19 February 2026

RE: Flooding Response to DPHI Request for Additional Information regarding the Brewongle Solar Farm (SSD-64834490)

A request for additional information was received from the Department of Planning, Housing and Infrastructure (DPHI) in response to the submissions report for the Brewongle Solar Farm (SSD-64834490). The following items relate to the *Brewongle Solar Farm Surface Water Impact Assessment (SWIA)* (Engeny, 2025):

Edify Brewongle Solar Farm  
Figure B12  
Flood - Probable Maximum Flood (PMF) Change in Peak Flood Depth  
Drg Ref. NTL00206\_0015-FIG-B12

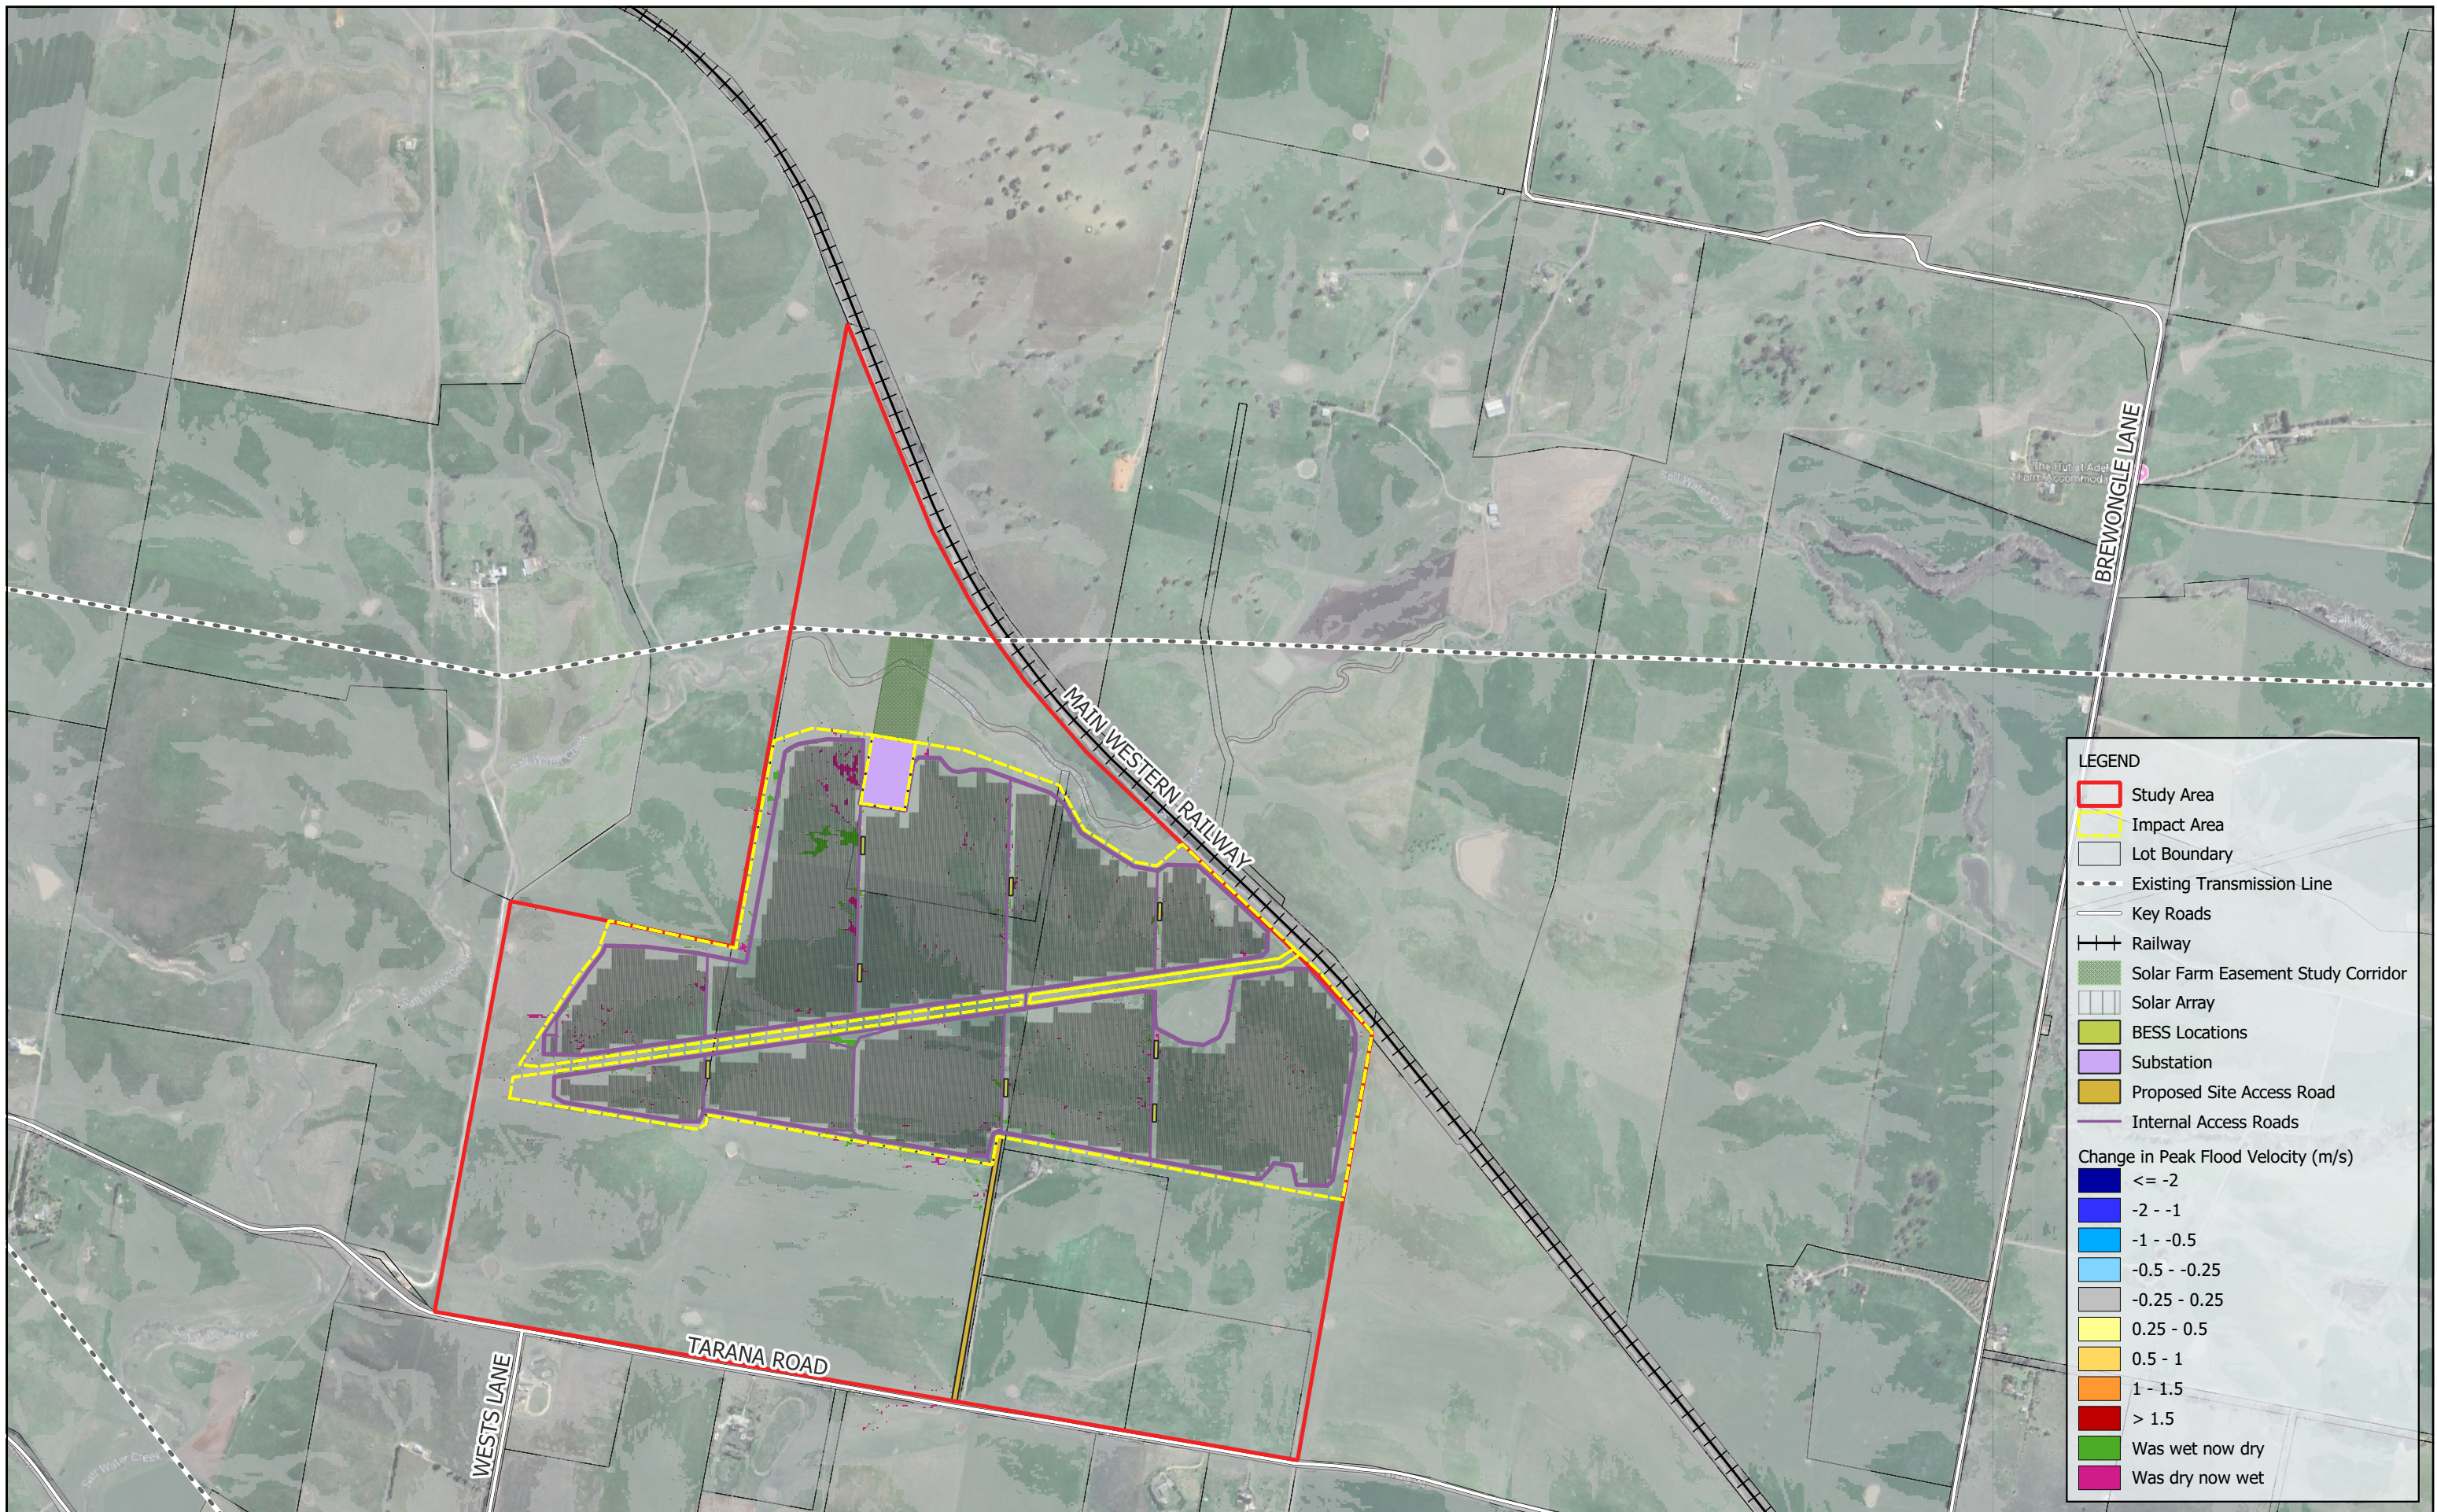
- *Details of measures proposed to avoid or mitigate off-site flood impacts.*
- *Clarify the off site flood depth increases shown in Figure B12, including:*
 - *Whether the relevant landowner/council has been consulted – to be addressed by lead EIS consultant.*
 - *What the affected area comprises.*
 - *How impacts would be mitigated.*

Figure B12 in the *Brewongle Solar Farm SWIA* (Engeny, 2025) presents the change in peak flood depth results for a Probable Maximum Flood (PMF) event. As identified in DPHI's response, Figure B12 indicates changes in flood depths outside of the Study Area, that is off-site impacts, in the PMF are expected adjacent to the intersection of Tarana Road with the proposed site access road, extending to the downstream property (Lot 1, DP1106759). The extent of off-site impacts is also shown on Figure 1 and include:

- Approximately a 100 m stretch of Tarana Road with increases in flood depth of up to 30 mm (refer to Figure 2). It is noted that flood depths along Tarana Road in the impacted area reach up to approximately 680 mm under baseline conditions (Figure A5 of the SWIA (Engeny, 2025)), which would already result in restricted access. Similarly, Figure A15 and Figure B9 in the SWIA show Flood Hazard in the H5 category under both baseline and developed conditions, with negligible change to the impacted section due to the development (Figure 3). The *Australia Disaster Resilience Handbook 7 – Managing the Floodplain: A Guide to Best Practice in Flood Risk Management in Australia* (AIDR, 2017) defines a H5 hazard category as unsafe for vehicles and people. The additional increase (30 mm) is therefore unlikely to cause additional access impacts or risks as the road is already impassable during the PMF event.

- Localised area (<0.3 ha) of downstream property (Lot 1, DP1106759) with increases in flood depth of up to 30 mm. The impacted area comprises of an access road. It does not appear to be a primary residential driveway. Figure A5 of the SWIA (Engeny, 2025) indicates that the entrance of this access road is expected to be inundated to depths greater than 500 mm, with a flood hazard category of H5 (unsafe for vehicles and people) under baseline conditions. Access in the impacted area would therefore already be restricted, and the additional increase (<30 mm) is therefore unlikely to cause additional risks as the access road is already impassable during the PMF event.

- Localised area (~0.6 ha) of downstream property (Lot 1, DP1106759) with decreases in flood depths of up to 80 mm. The impacted area is largely associated with an existing flow path, downstream of a farm dam. Changes to flow depths are considered minor.

The observed off-site impacts are likely attributed to the assumed reduction in Manning's 'n' roughness (surface resistance) and increased impervious nature of the proposed site access road. Within the road footprint, Manning's 'n' roughness decreases from 0.045 (Grassland with Low Density Vegetation) to 0.015 (Roads and Other Hardstands). This reduction in surface roughness (i.e. resistance), combined with higher runoff potential of impervious areas, increases flow conveyance through the road alignment. As a result, flows become more concentrated downstream, contributing to the observed off-site impacts.

It is considered that the off-site impacts can be minimised through appropriate road design, which would be addressed during the detailed design stage (post approval). This is expected to include optimising road grading, and drainage controls to maintain baseline flow paths and reduce downstream impacts. Future flood modelling during post approval is recommended to inform the detailed design.
